CITY OF PORTLAND, MAINE
DEVELOPMENT REVIEW APPLICATION
PLANNING DEPARTMENT PROCESSING FORM
DRC Copy

2006-0103
Application I. D. Number
5/26/2006
Application Date
Single Family Home
Project Name/Description

Beaumont St, Portland, Maine
Address of Proposed Site
294 C062001
Assessor's Reference: Chart-Block-Lot

RE: Application for single family house, Beaumont Street

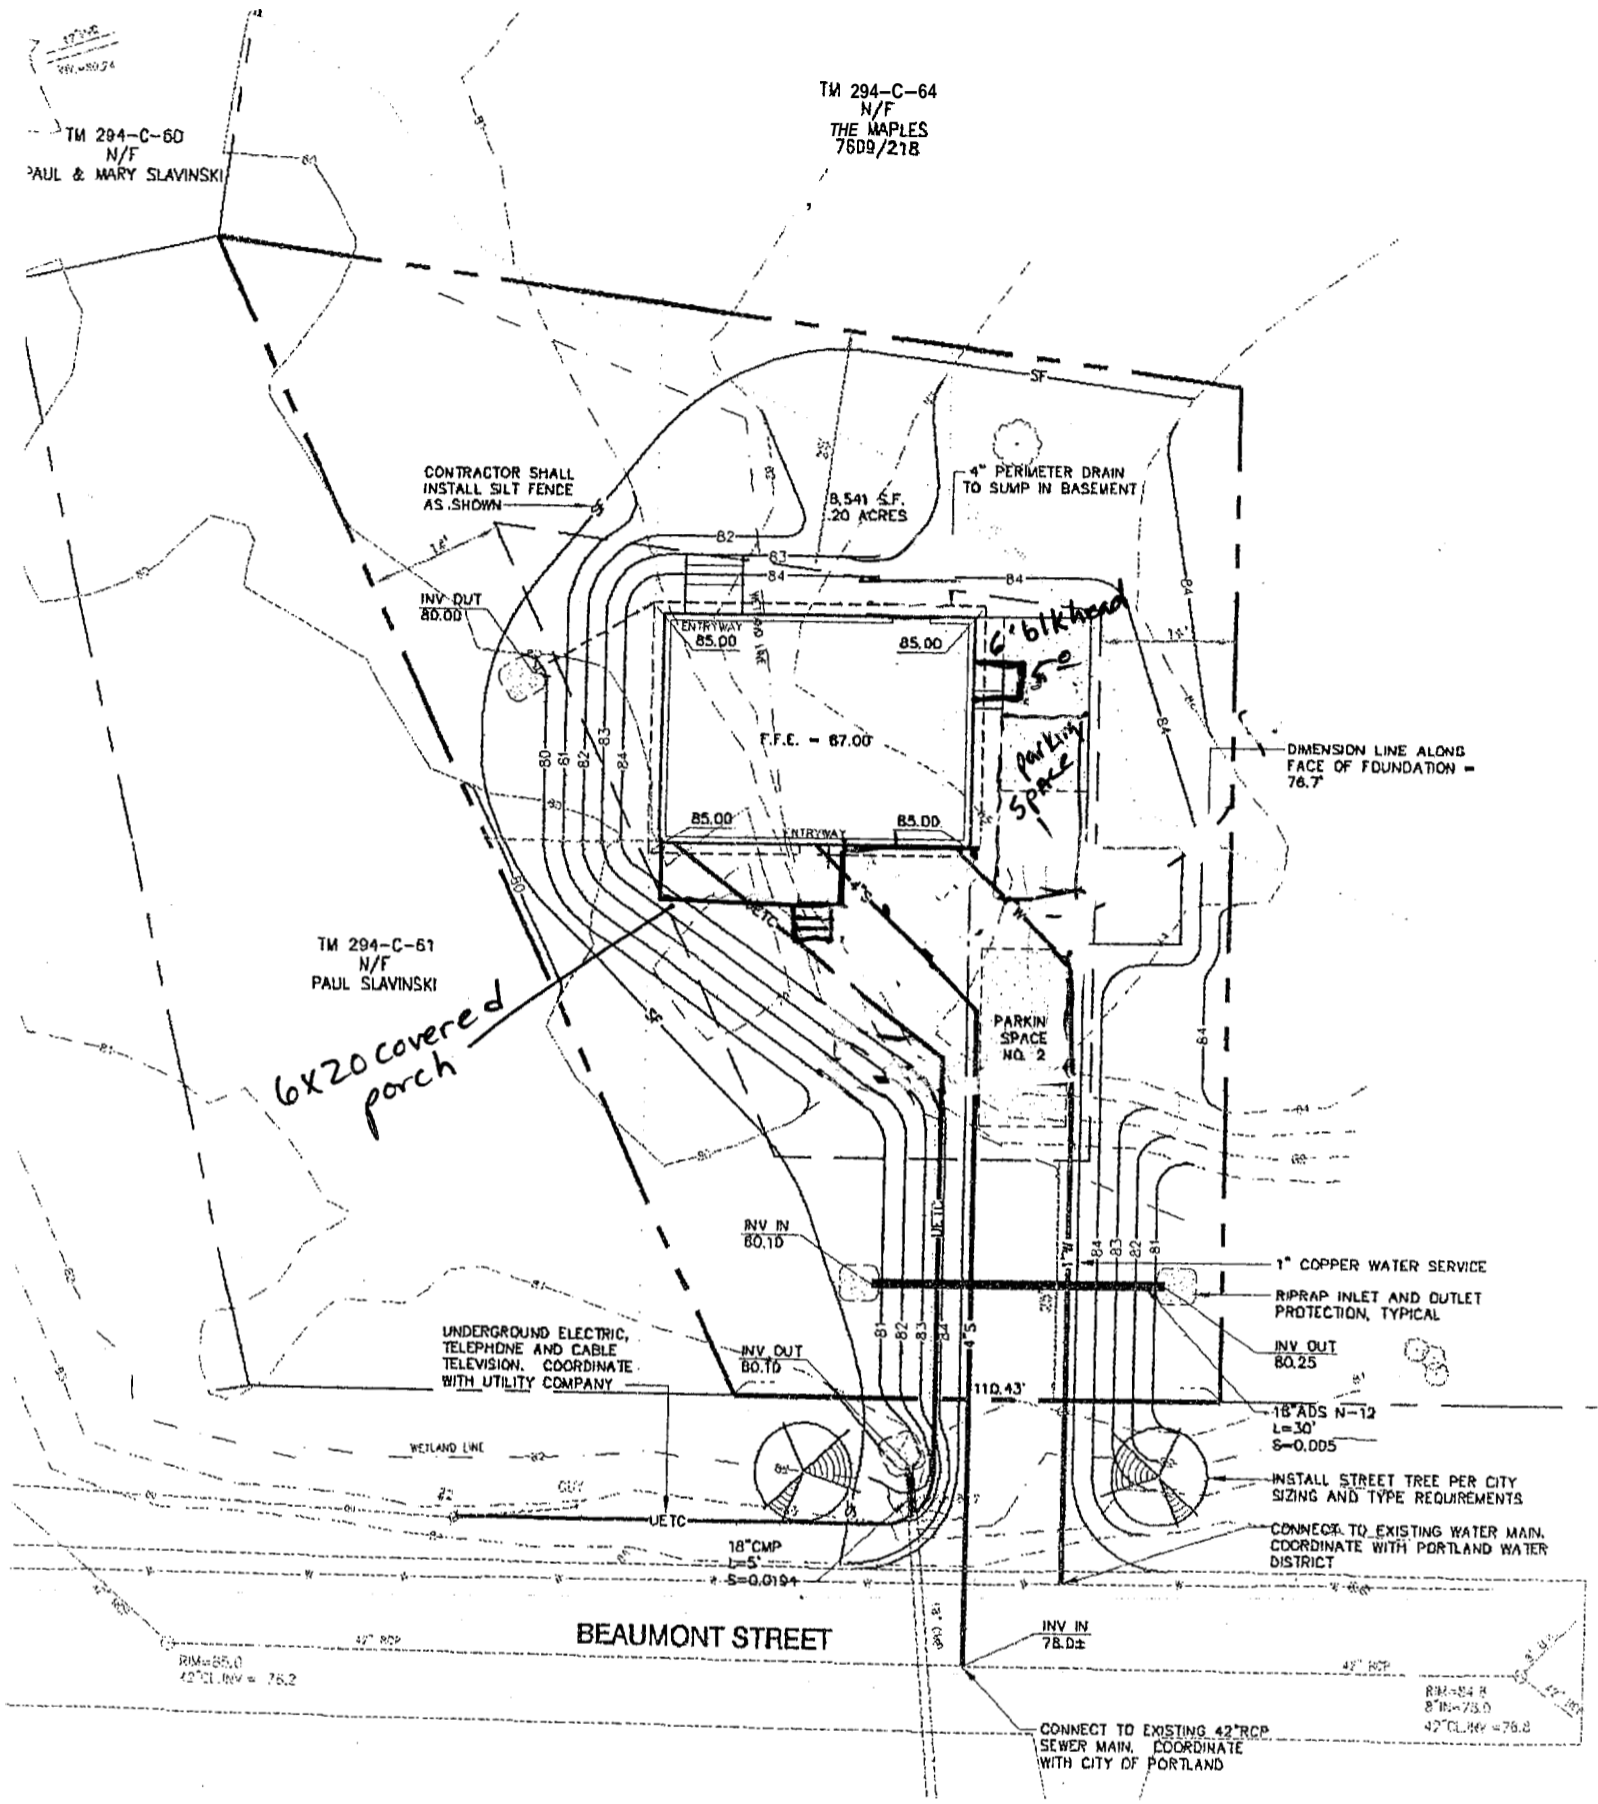
4. Please have your engineer provide information that shows that the proposed 18" culvert is adequately sized.
5. Please transfer the wetland information from the survey to the site plan. Also, please show the areas of wetland impact including the total square footage of wetland loss.

B. Wetlands: The DEP has authorized us to fill up to 4300 square feet of wetlands on the site. The actual wetlands impact as noted on the revised site plan will only be 2879 square feet. ✓

Paragraph 4: Culvert Sizing: Attached find a letter from Stephen Bradstreet, P.E. addressing the culvert sizing. ✓

OK
Paragraph 5: Wetland Delineation: The wetlands already were delineated on the site plan, but apparently they were too light, so we have darkened them for easier viewing.
